Online Comment

Application H17-0190-21
Location Land at Gubboles Drove Surfleet Spalding PE11 4AU
Proposal Change of use of land to dog training centre with associated works - re-submission of H17-0239-20

Atomic Dog Training Centre

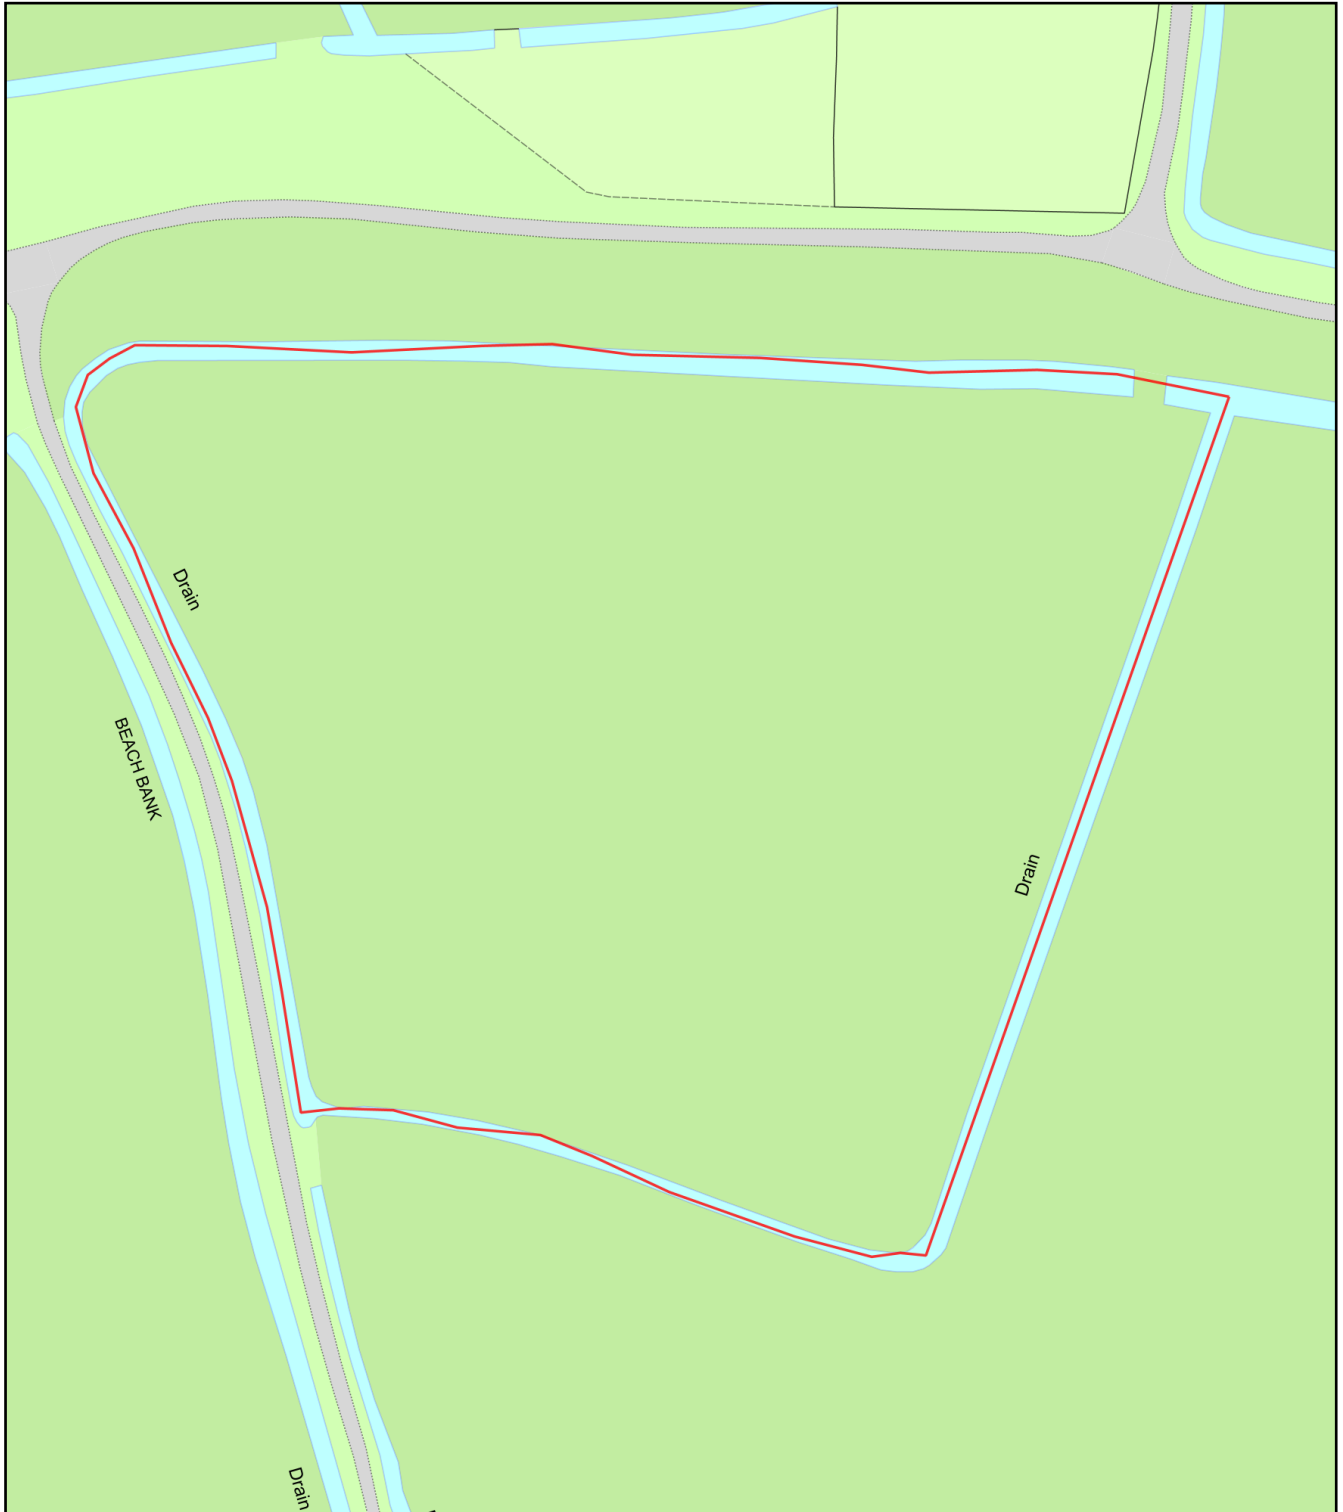
After looking through the extra information my objections still stand as none have been addressed. This new access which I don't believe can be achieved, now passes the entrance of the neighbouring agricultural field and runs along the highway I struggle to see how this will be maintained as it is on land that is not in the applicants ownership
